From: Daun Johnson
Sent: 01 March 2022 07:24
To: Planning.Responses
Subject: FW: Planning Application Ref: K/2/22/HH - 43 Golden Avenue : OWPC 44627 - Objection

Subject: Planning Application Ref: K/2/22/HH - 43 Golden Avenue : OWPC 44627 - Objection

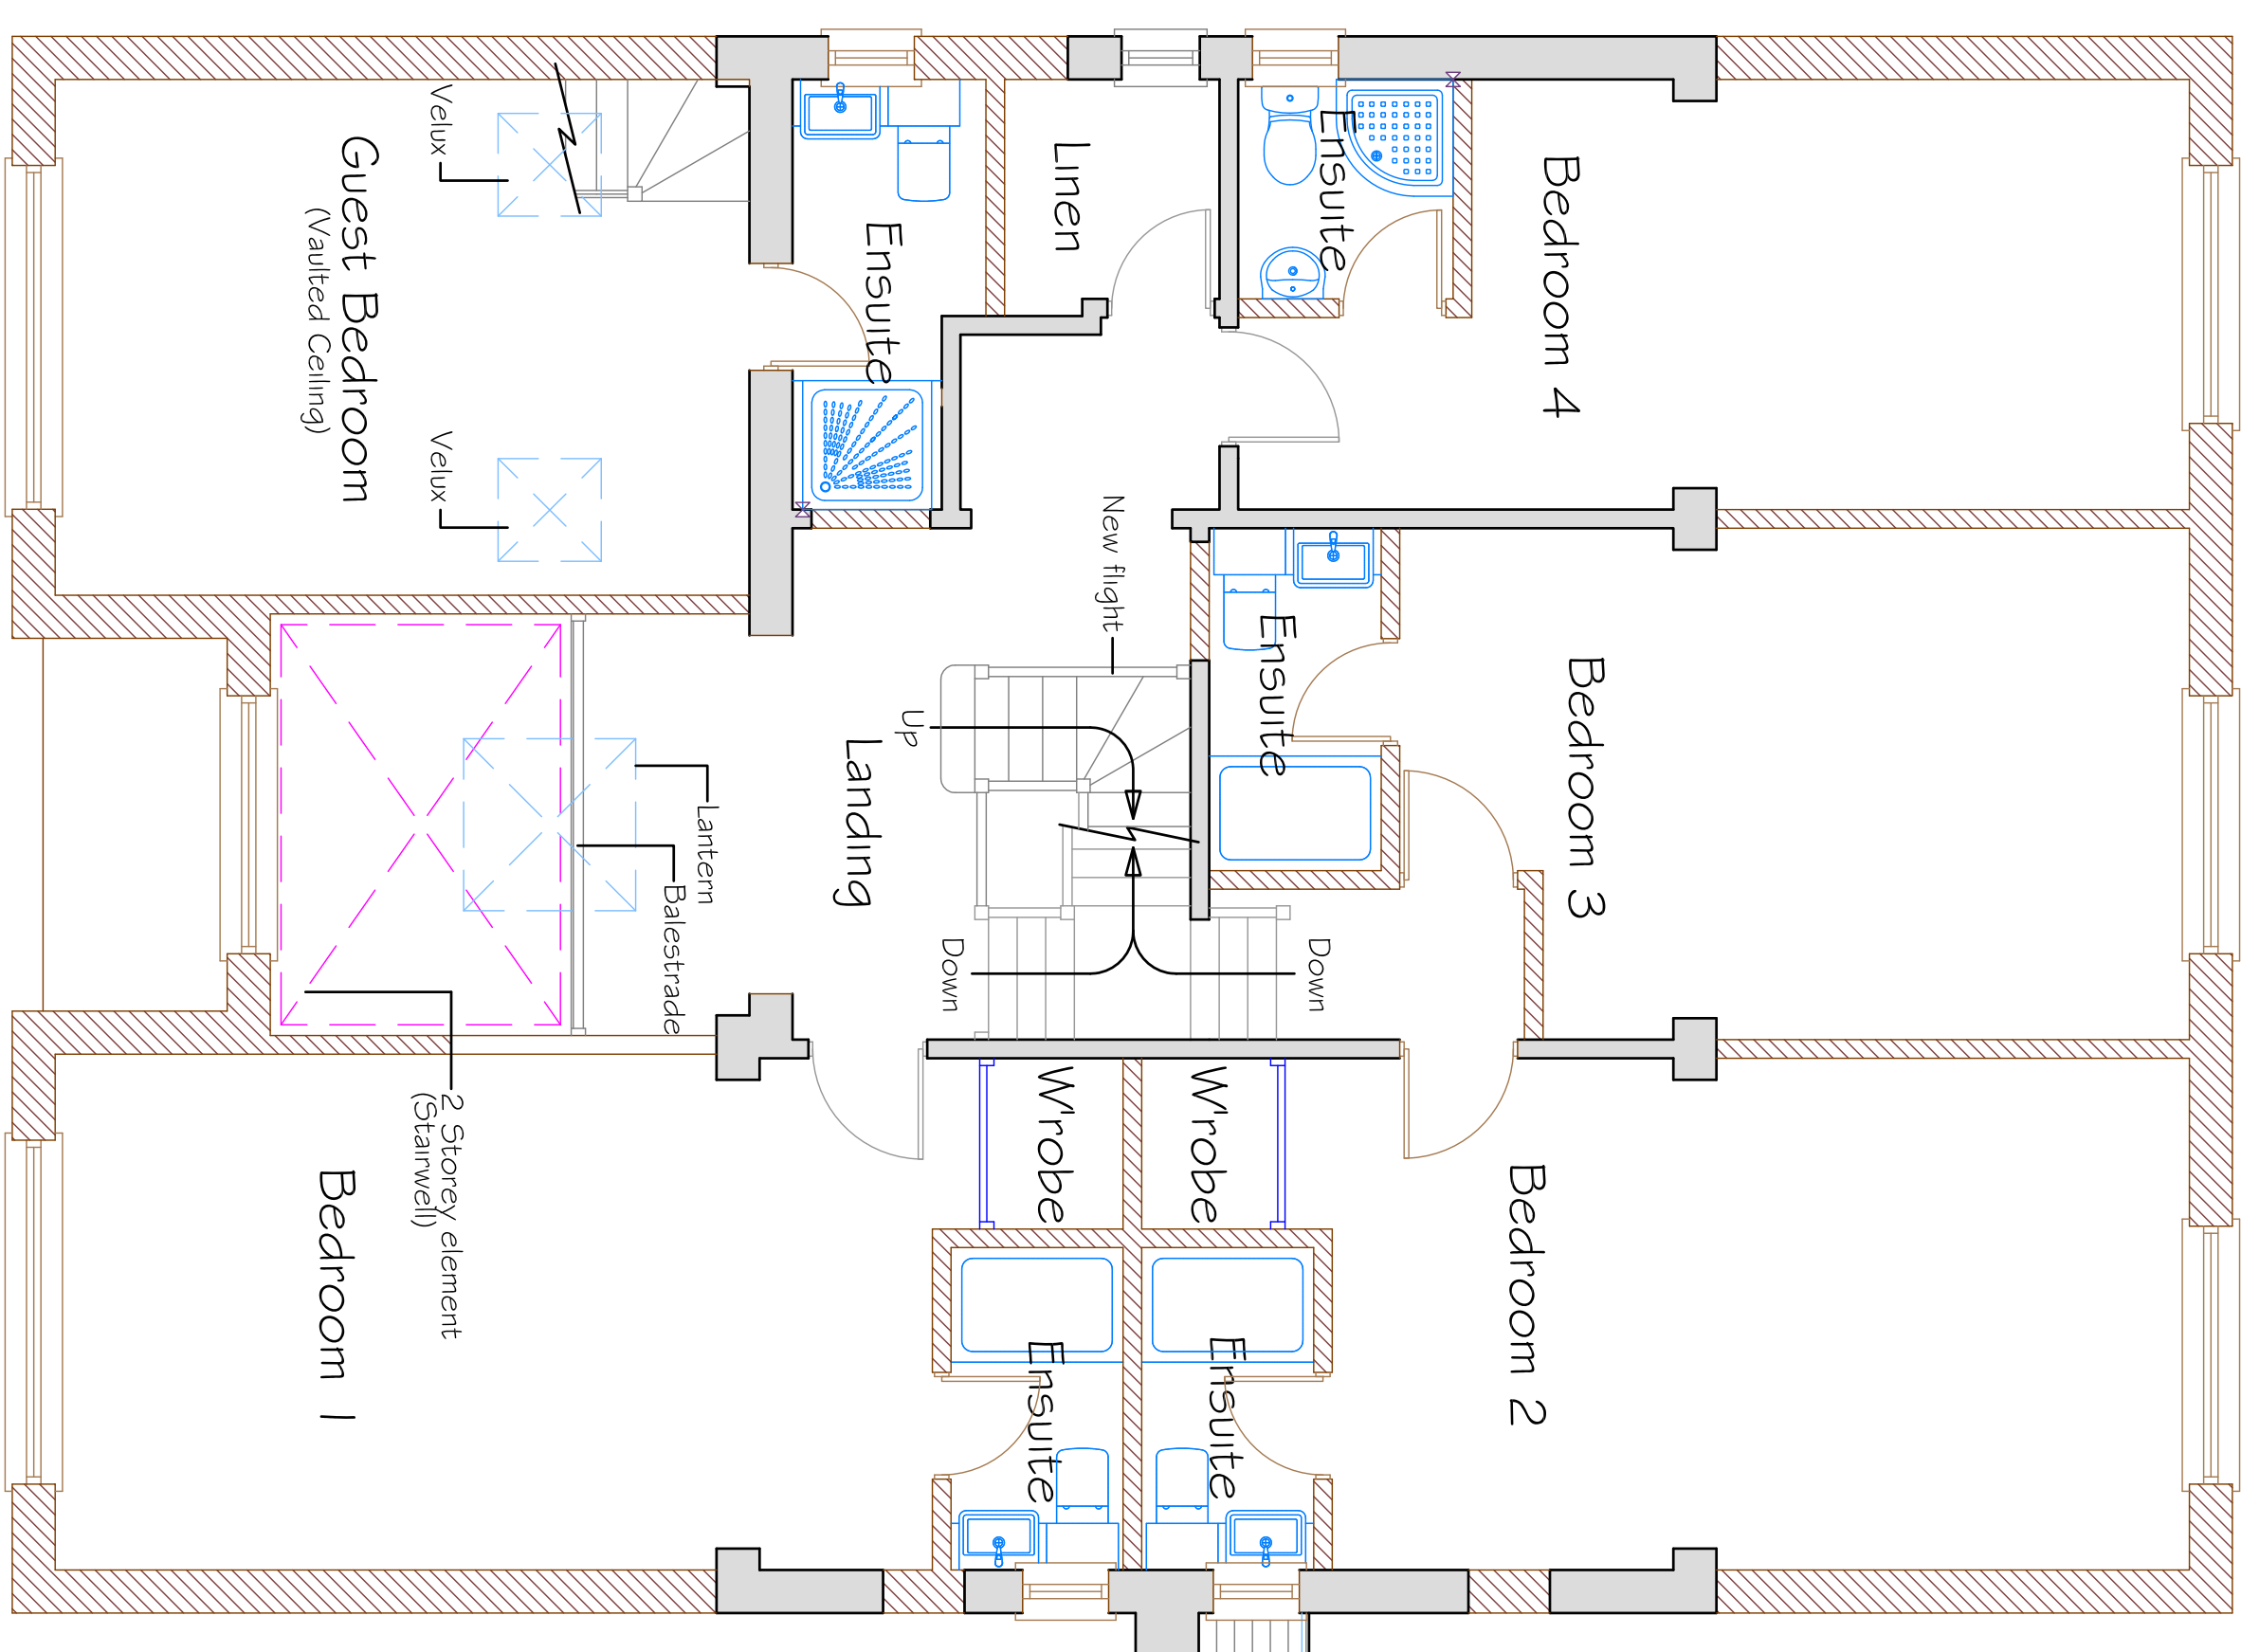
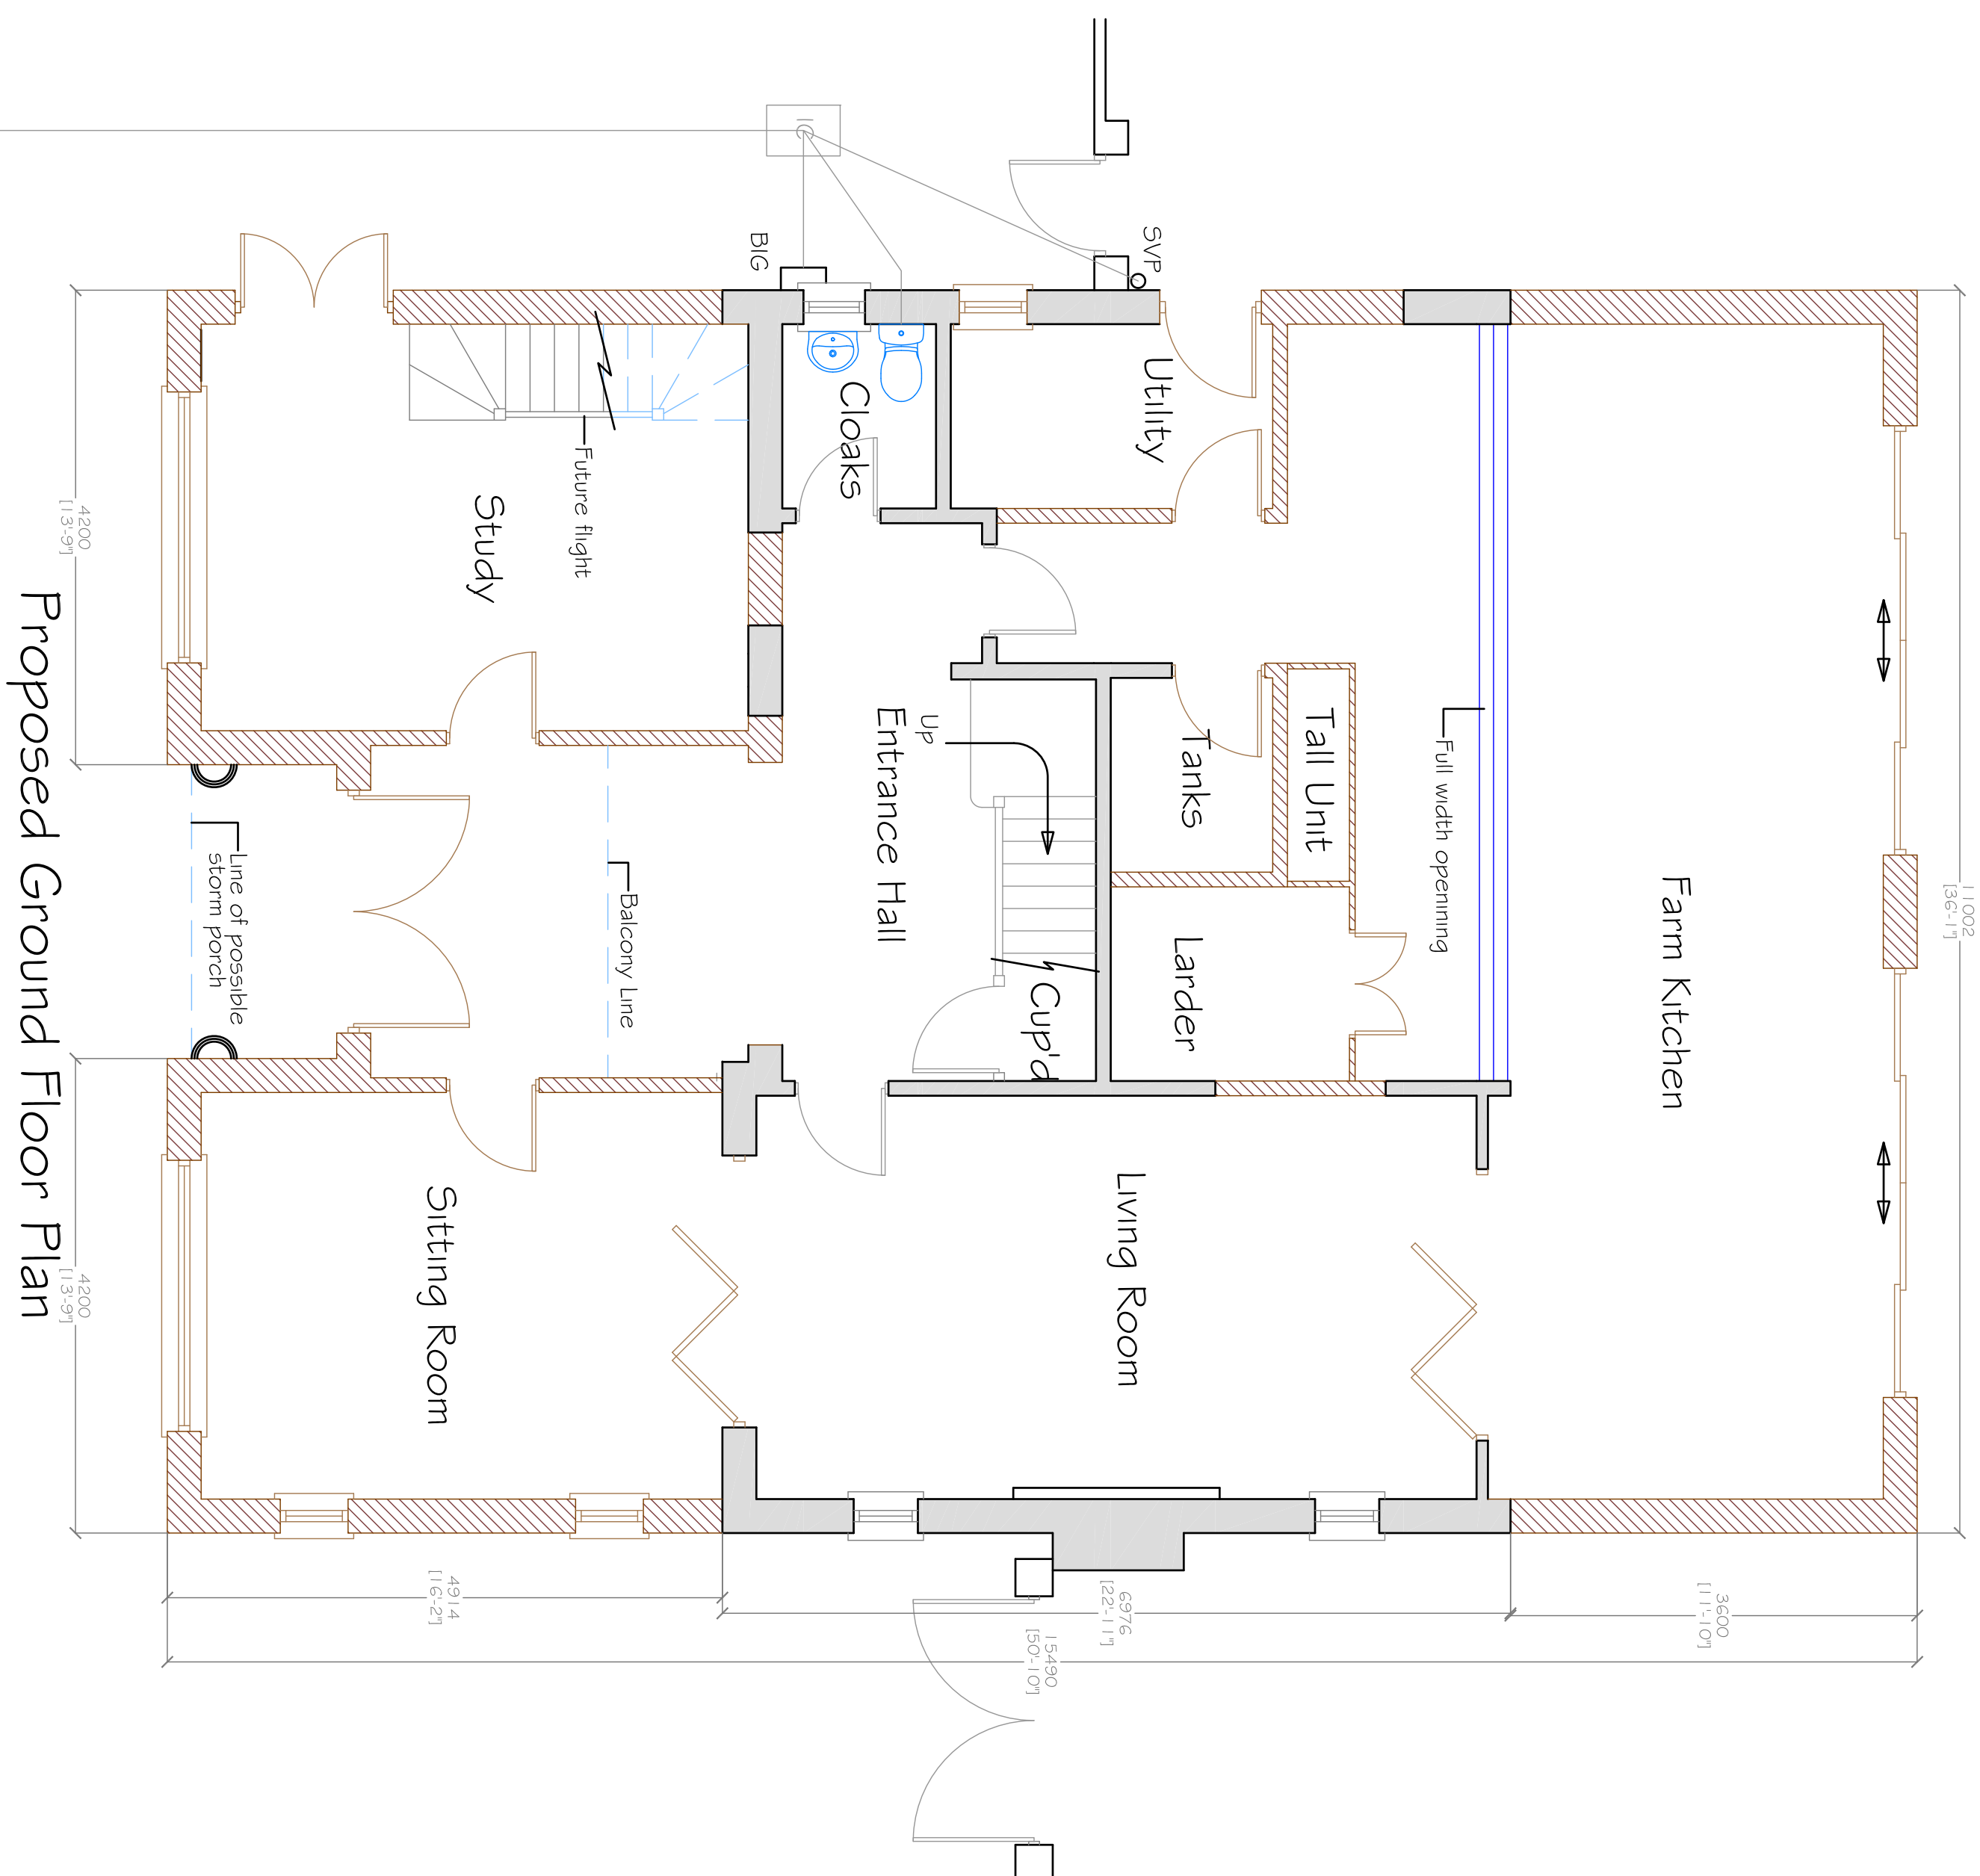
The drawings show that the new extensions and the entrance to the front of the property will be built over the current car spaces and garage. Drawings do not include for a parking area for six cars.

Drawing: STREET SCENE/PARKING

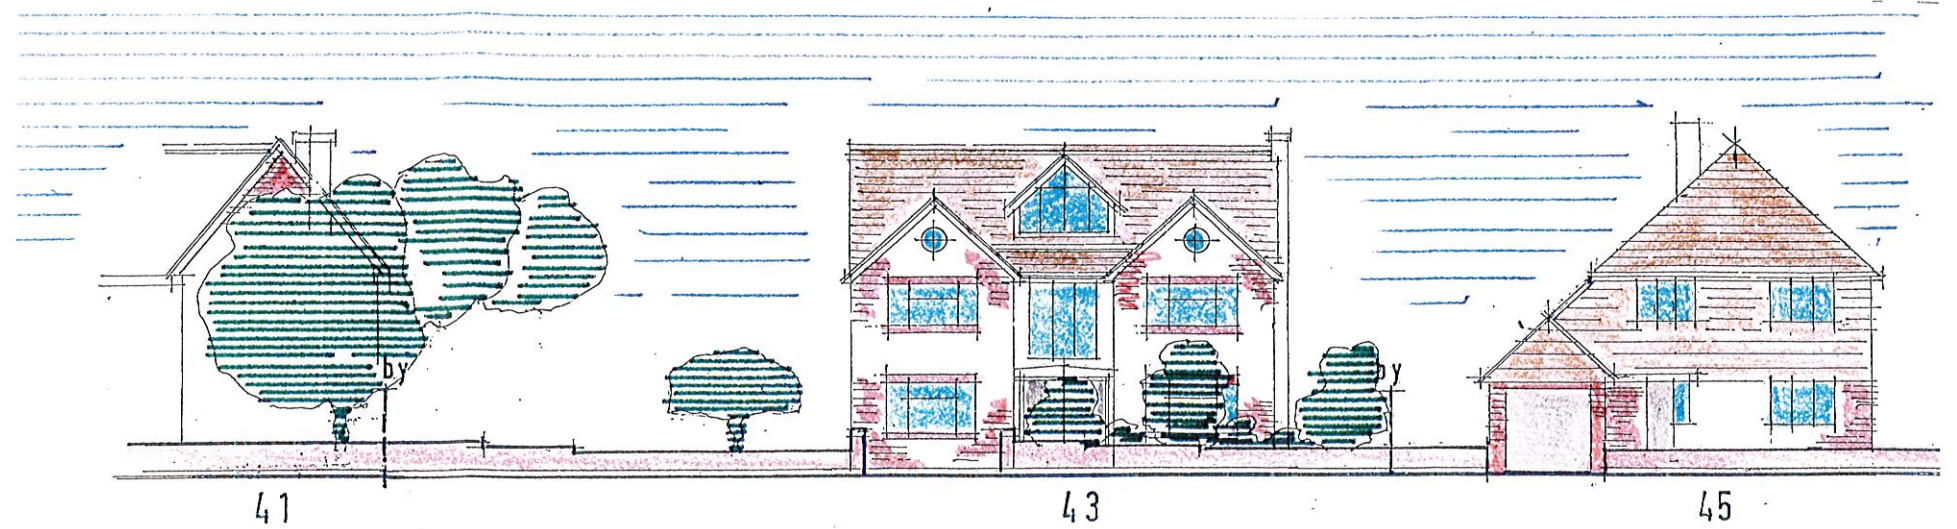
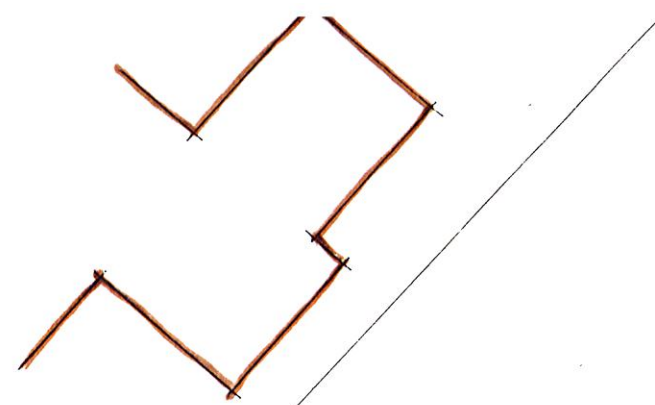
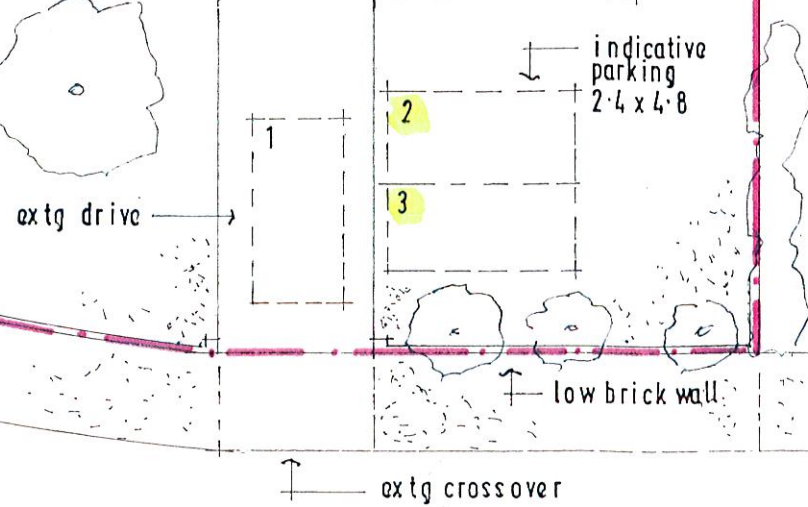
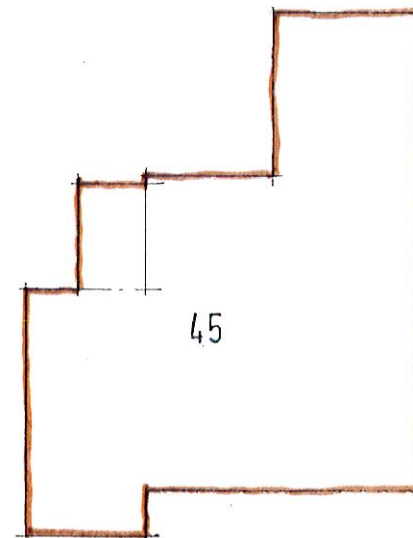
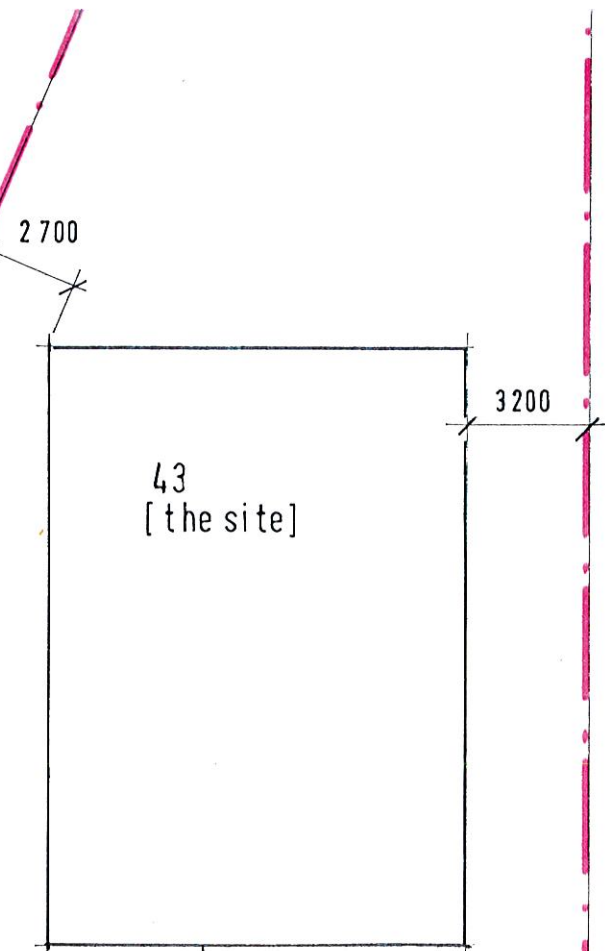
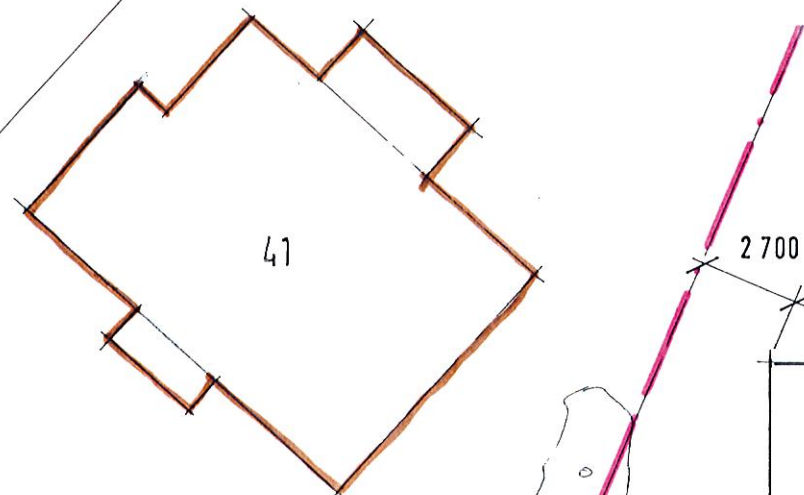
From my neighbour’s planning application for the section on parking, this was incorrectly filled in and he confirmed that the proposed works will not affect the existing parking arrangements on the property.
